From: Bob Sharples <Bob.Sharples@sportengland.org>
Sent: 06 October 2021 08:47
To: Wayne Campbell
Subject: App Ref: 21/03039/F - Sibford School - Sport England Ref: PA/21/SE/CL/59823

The proposal is for the Demolition of existing sport pavilion and erection of a new pavilion.

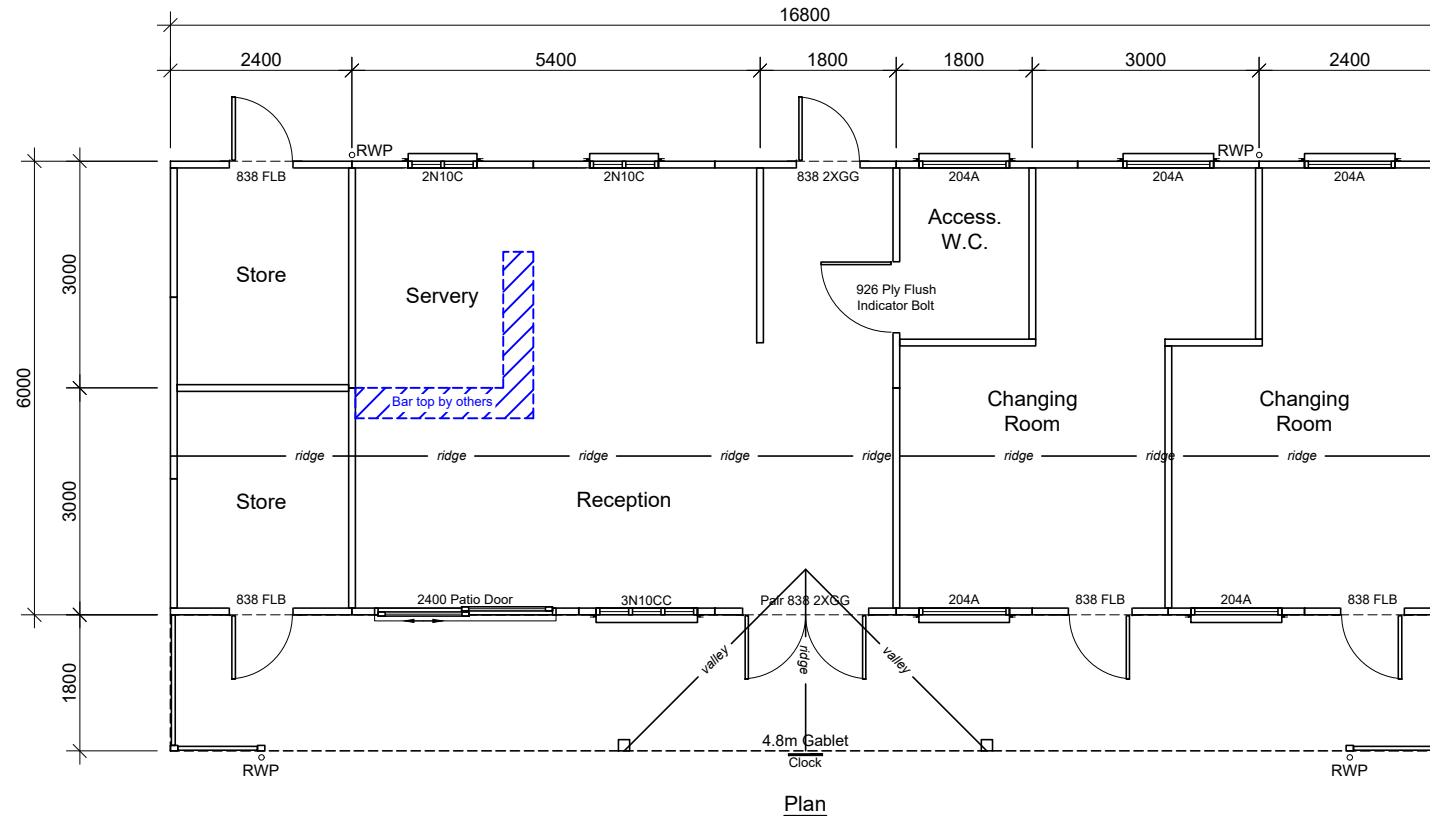
I reviewed the scheme and note proposal is one the same print as the building which is to be demolished. Looking at the internal layout, having only one WC appears to be light on provision and I think I tis a missed opportunity not provide at least two shower cubicles, after all we are in the 21st century and personal hyenine is something which young people take seriously. It has been shown that if there is no showering provision, it can be a barrier to participating in sport some people.
